**Consultation Response from KC,
Conservation & Design**
2024/90099 Mellbreak, 161, Causeway Side, Linthwaite, Huddersfield, HD7 5SJ
Erection of dormer windows and orangery to rear (within a Conservation Area)
Date Responded: 03.02.2024
Responding Officer: S Pickles
Responding Ref:

The application is for retrospective works which include the erection of a full-length roof dormer to the western roof plane and the erection of as described rear orangery.

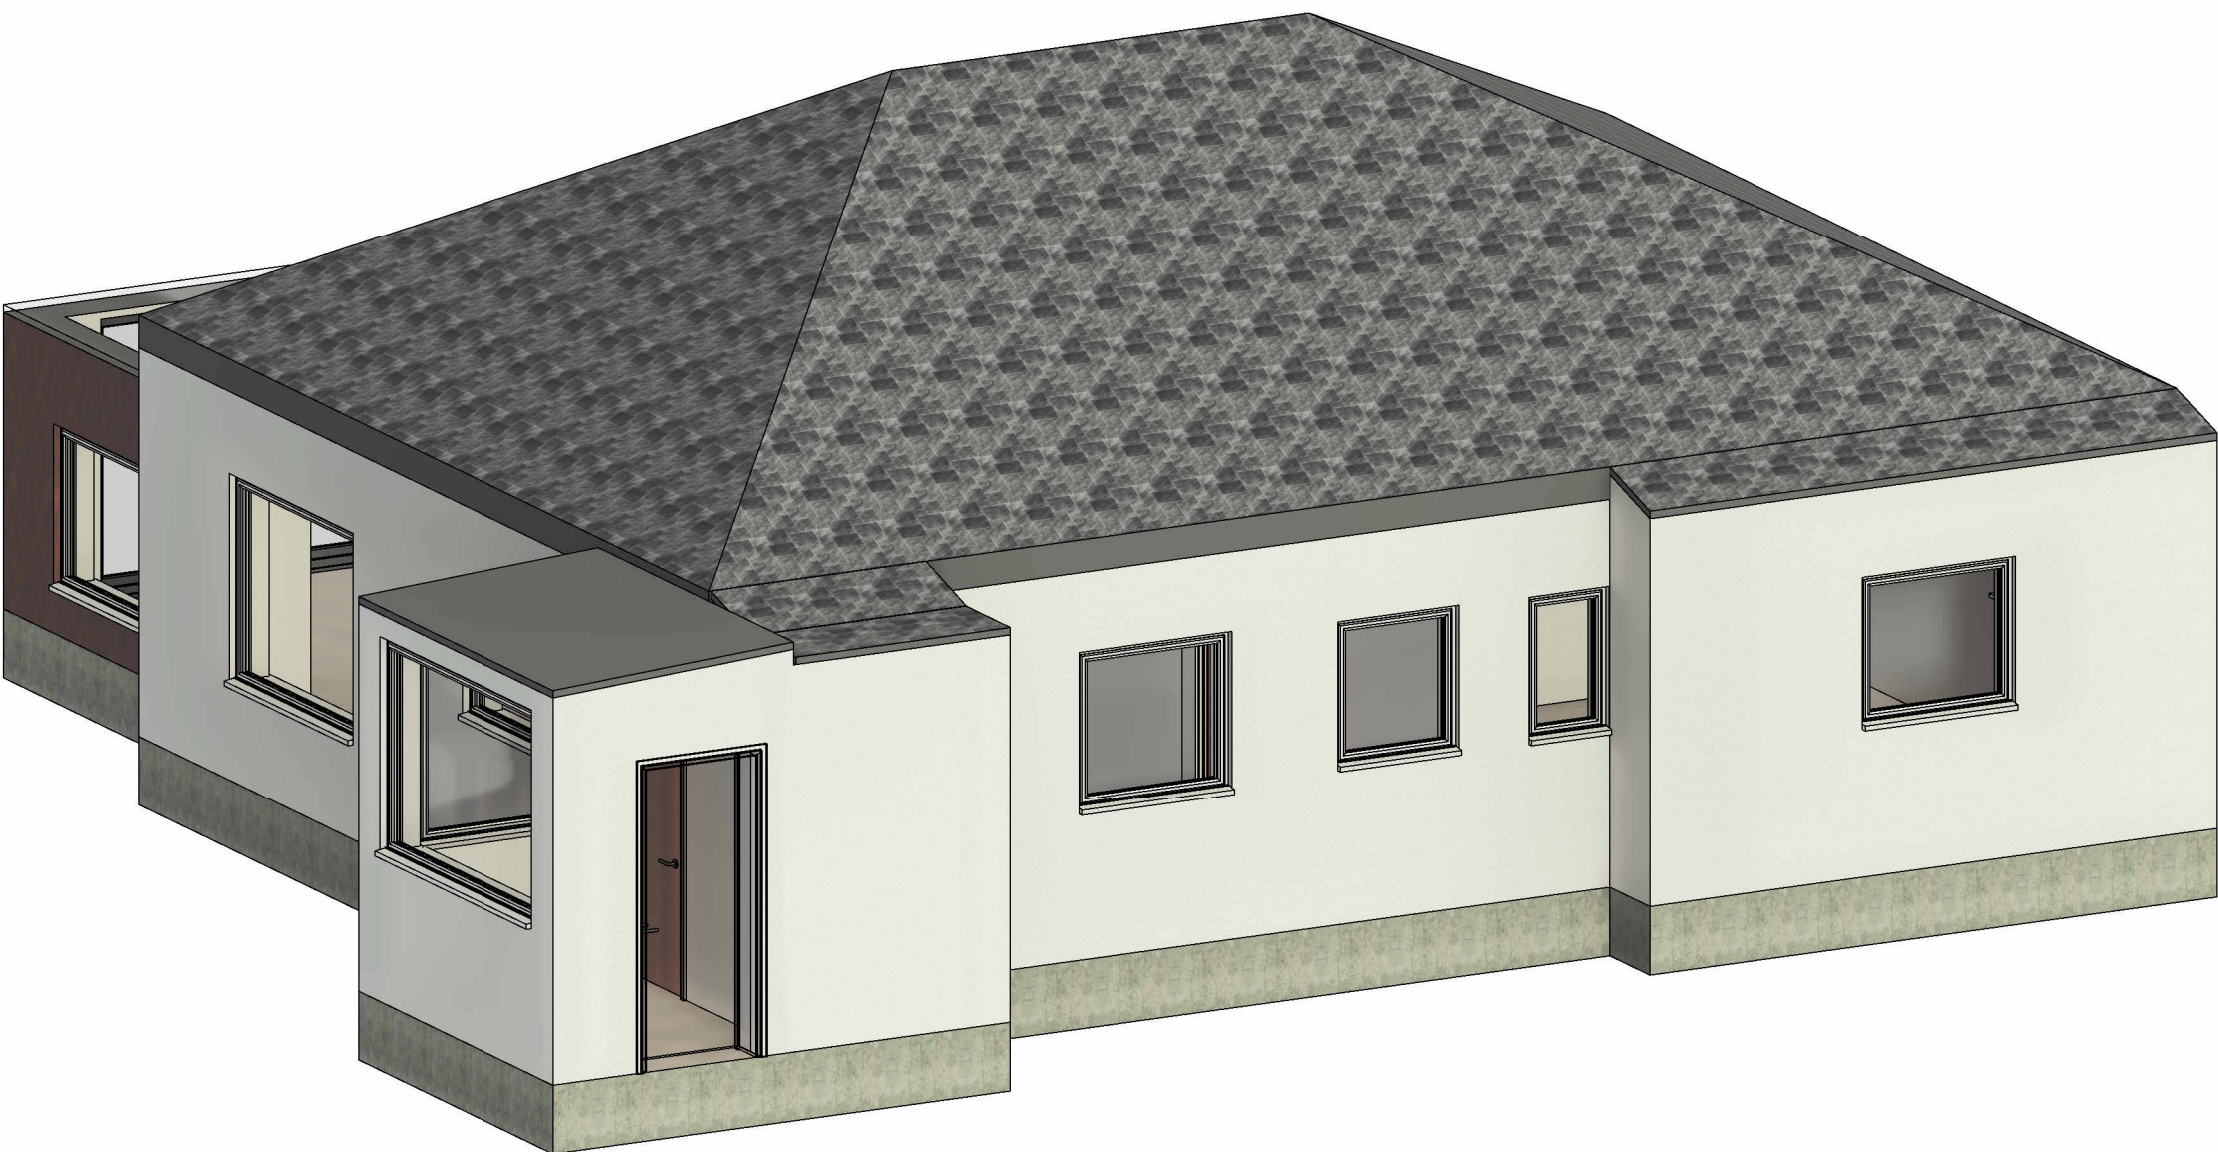
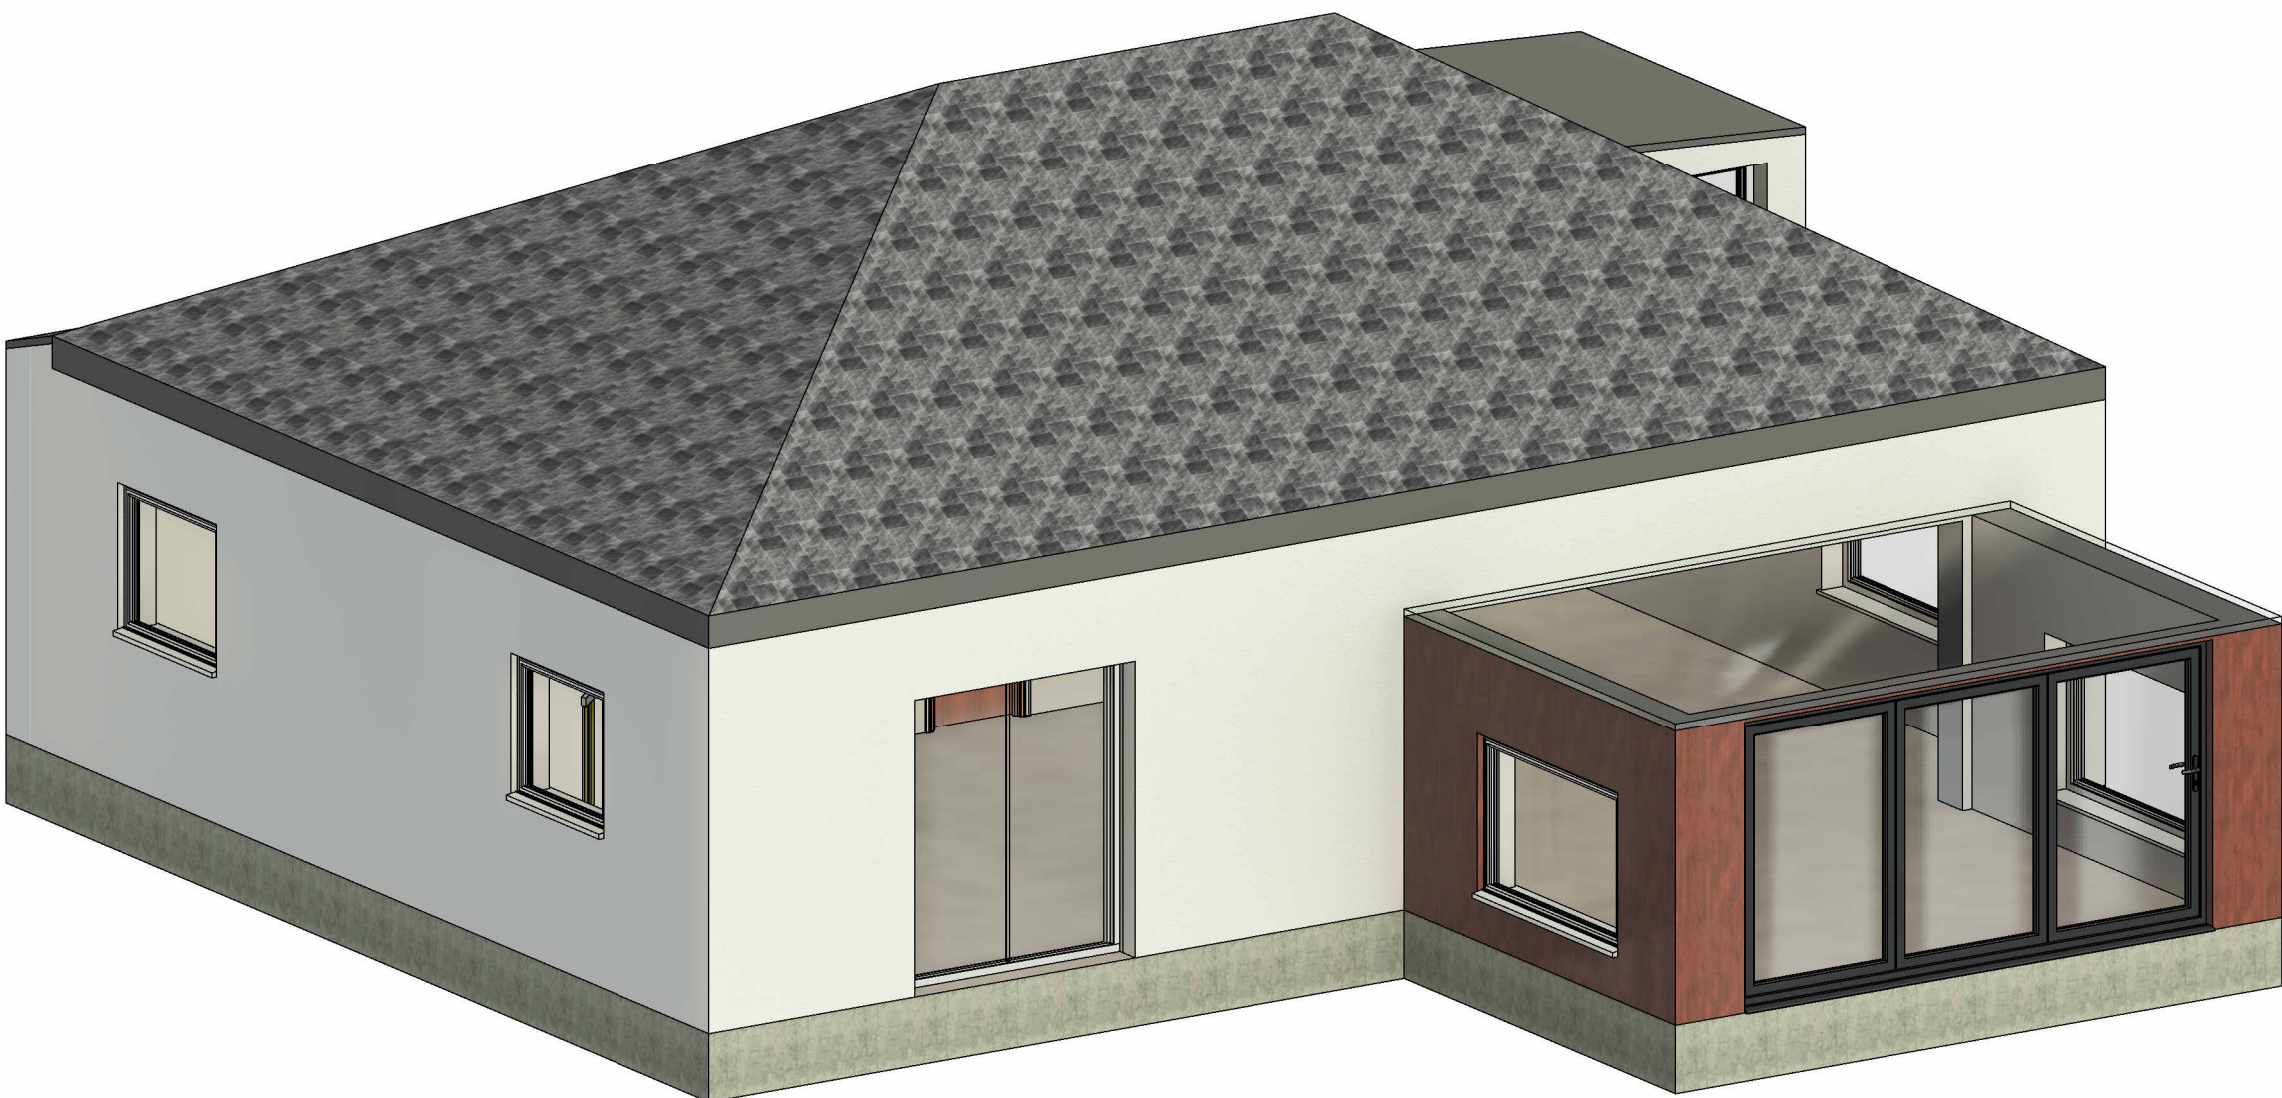
Given the works have already been carried out, the impact is more apparent. While the dormer is situated to the western roof plane as it is a full-length dormer and more of a roof extension the visual impact is high and the roof extension can clearly be seen. It is also clearly visible from the previously noted site line from No.215-219 Lane Top. When looking at previous street view images the application site can just be seen, however, the impact has considerably increased with the addition of the roof extension and rear extension.

While we recognise that the bungalow is a later addition to the area, it does fall with the setting of the listed building and is an entry point to the Conservation Area. We are unable to support the overly dominant dormer extension, which is more of a full roof extension and causes harm to the setting of the listed buildings and the way they are experienced. We have slightly lesser concerns in regard to the rear extension. We consider that the proposals do not meet the tests of national or local policies.
